Application no: H02-0181-10

Description: Proposed two-storey extension and conservatory

Location: 1 Low Road
Crowland
Peterborough
PE6 0BX

ACKNOWLEDGEMENT OF AMENDMENT

DRAWING B/102

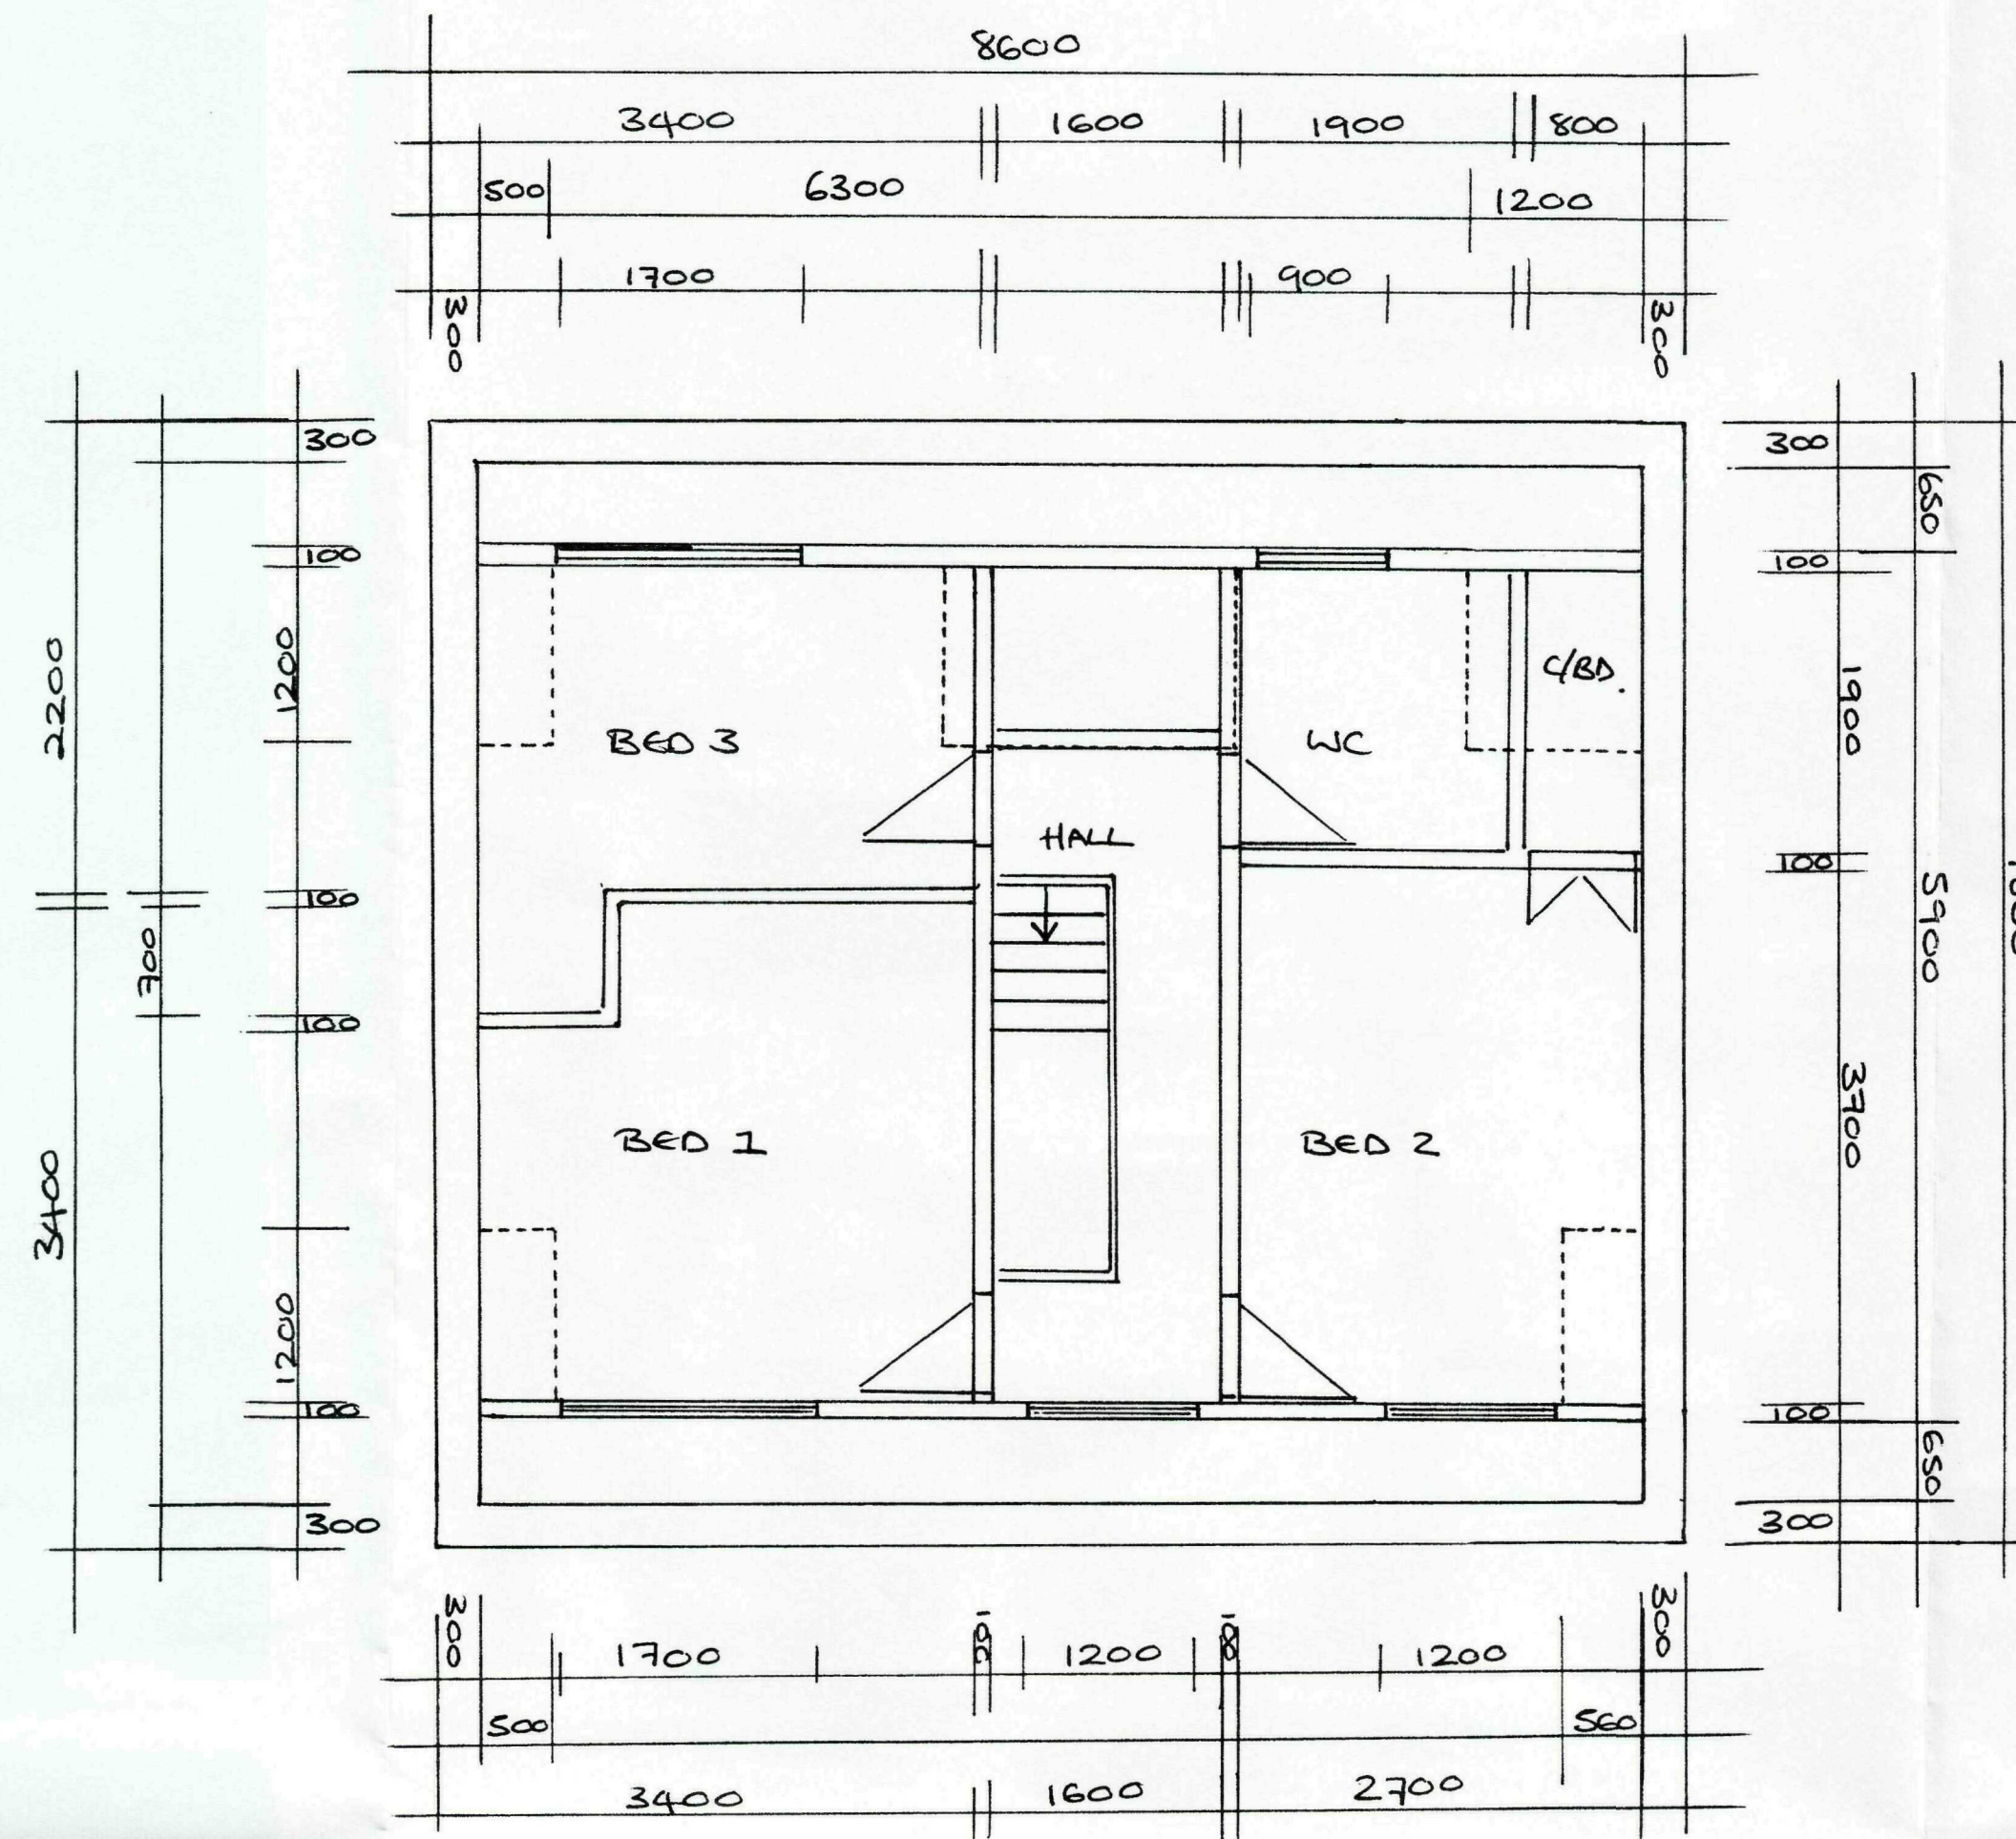
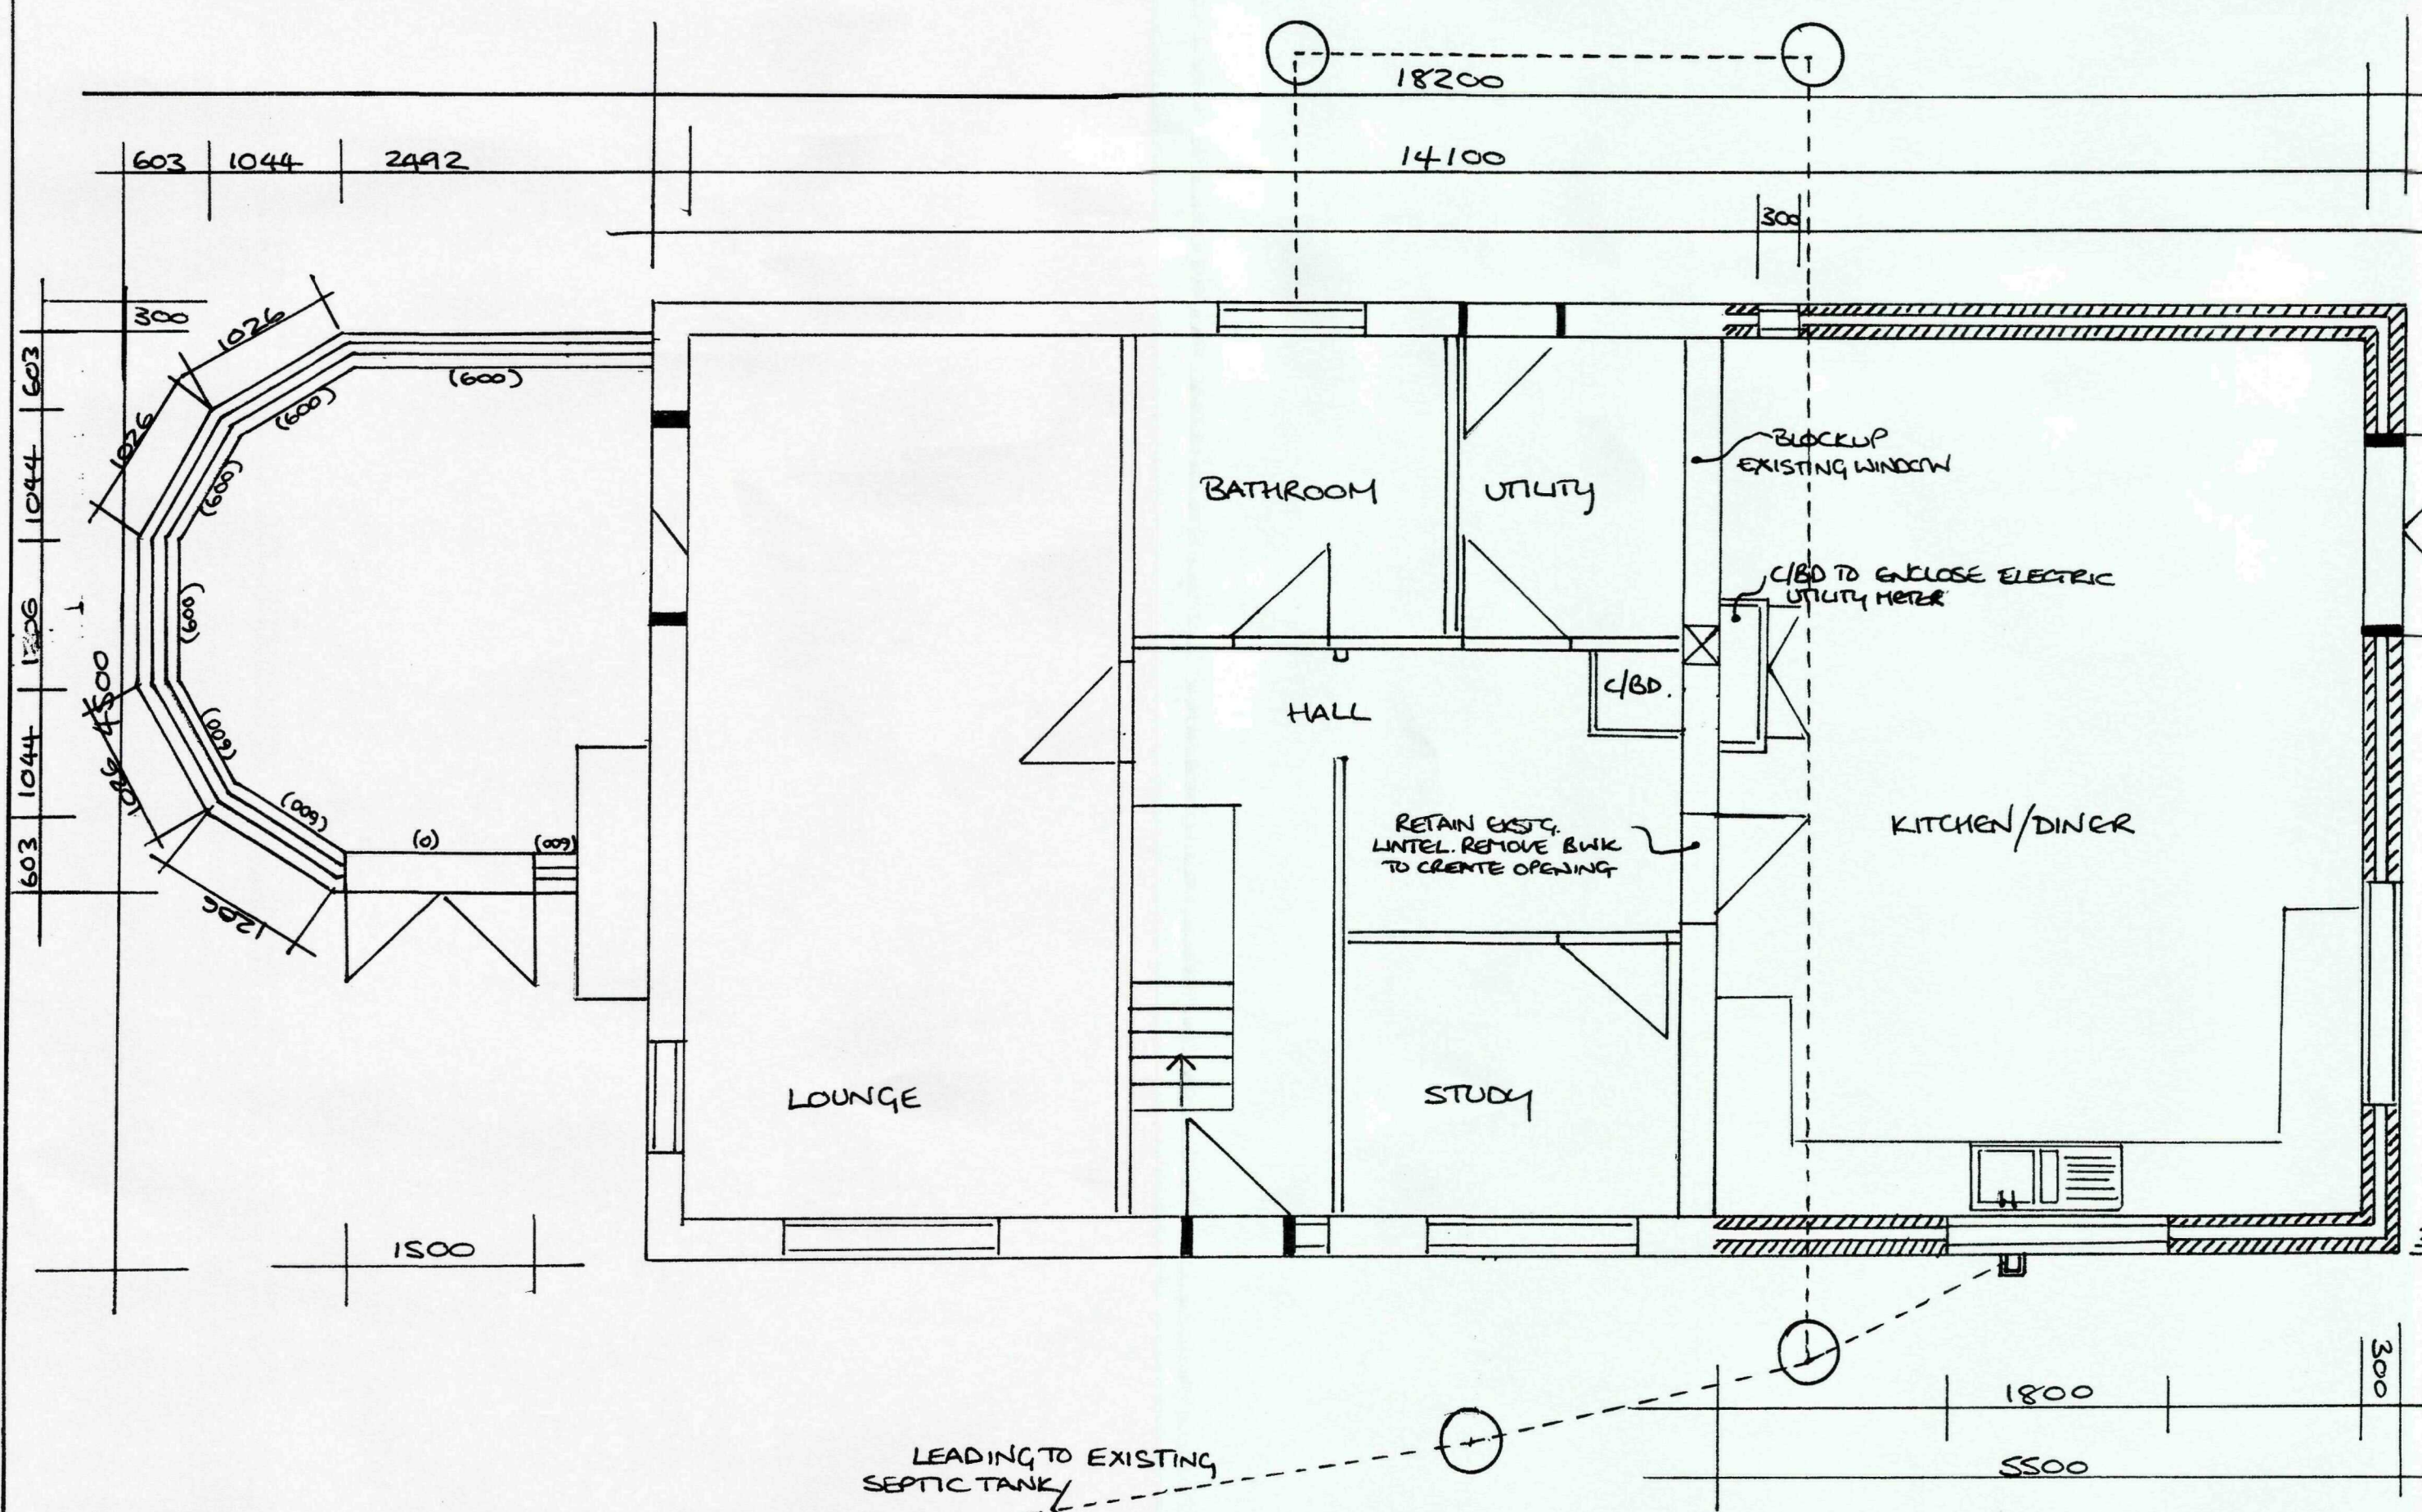
Amendment: Extension to be reduced by 1 metre
(dwg. nos. B/101/A and B/102/A)
